## **Application by Liverpool Bay CCS Limited for an Order Granting Development Consent for the HyNet Carbon Dioxide Pipeline Project.**

### **The Examining Authority's second round of written questions and requests for information (ExQ2) Issued on 15 June 2023**

DRAWING NUMBER
EN070007-APP-ES-17.4-Sheet 1

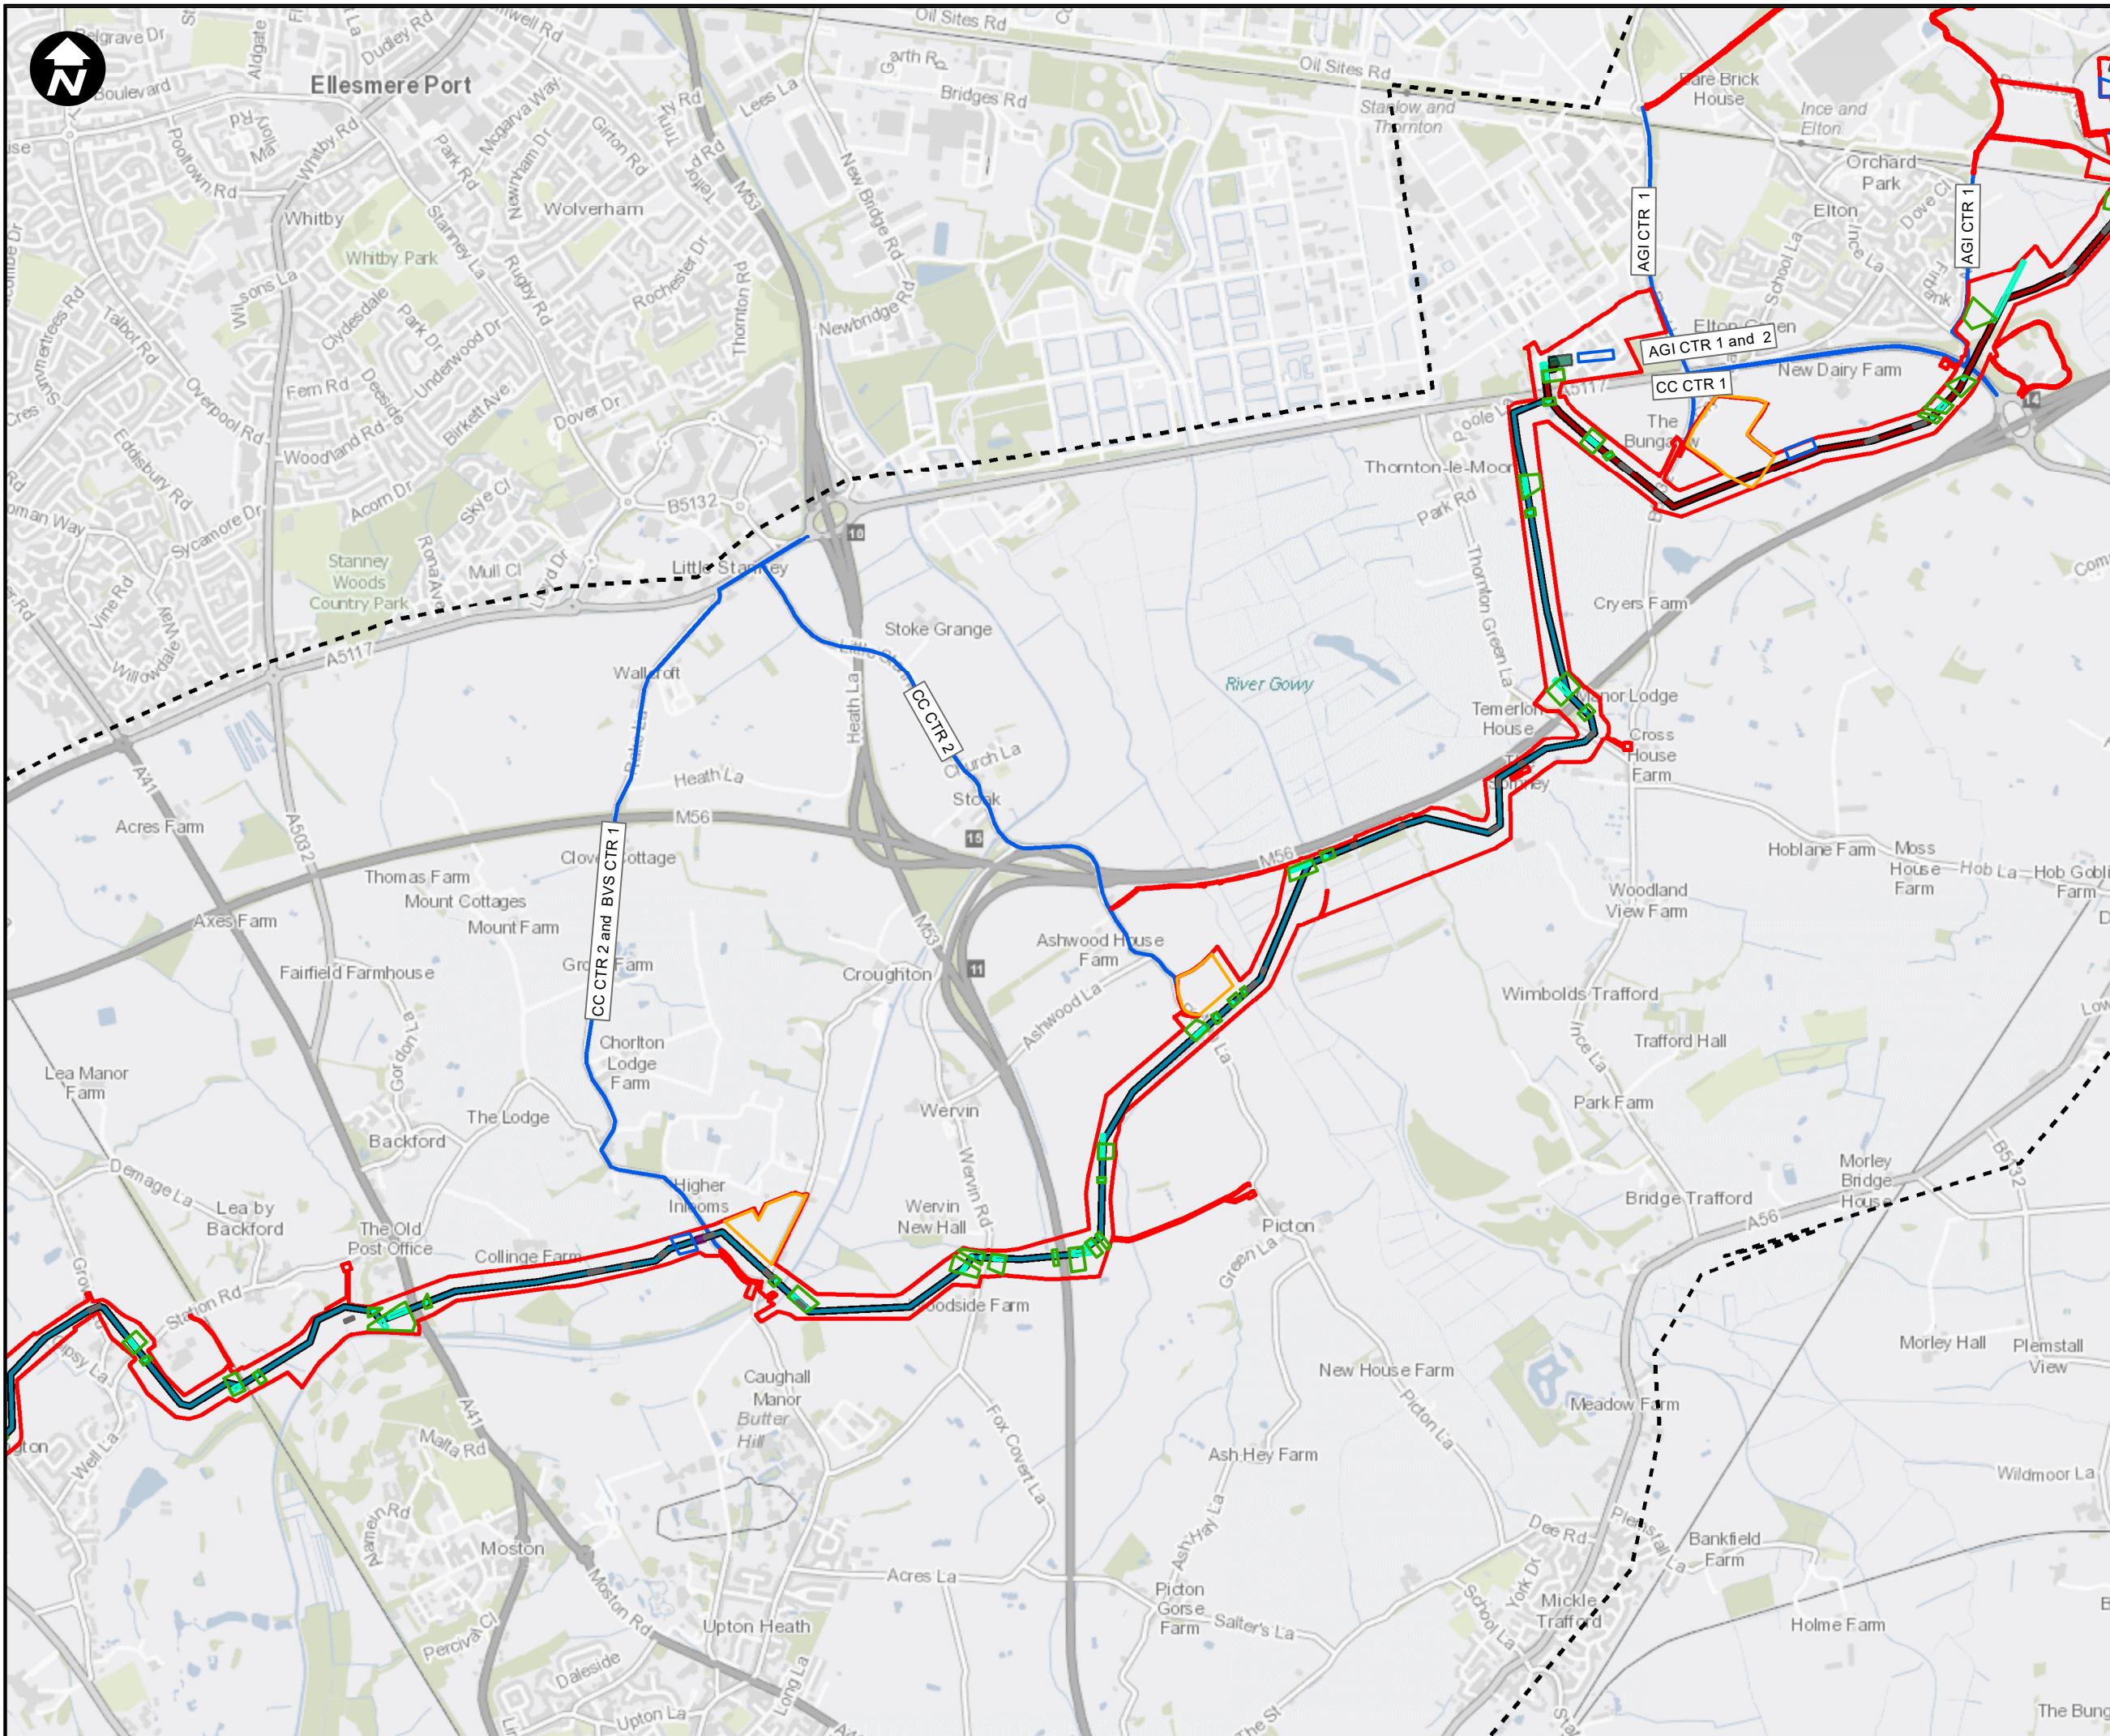
Q2.1.3	<i>Clarification</i> <b>Applicant</b>	<ul style="list-style-type: none"> <li>Figure 17.4 (Construction Access) [CR1-092] is unclear in regard to AG1 CTR1, which appears to be obscured by the red line Order boundary. Please review and amend, if required.</li> </ul>
Q2.1.4	<i>Clarification</i> <b>Peel NRE/ Cheshire West and Chester Council (CWCC)</b>	<ul style="list-style-type: none"> <li>Peel NRE references "Future Planned Infrastructure" in its submissions. Can it elaborate on what this means? (e.g. Is it referring to an existing allocation in the adopted Development Plan, or other development proposal(s) it is referring to). The Applicant in its 'Response to Written Representations' [REP2-041] at paragraph 2.11.15 states it is "<i>engaging with the IP to secure details of this infrastructure to ensure the separate developments can co-exist.</i>" Has such engagement with IPs including Peel NRE and CWCC occurred? If so, what was the outcome?</li> </ul>
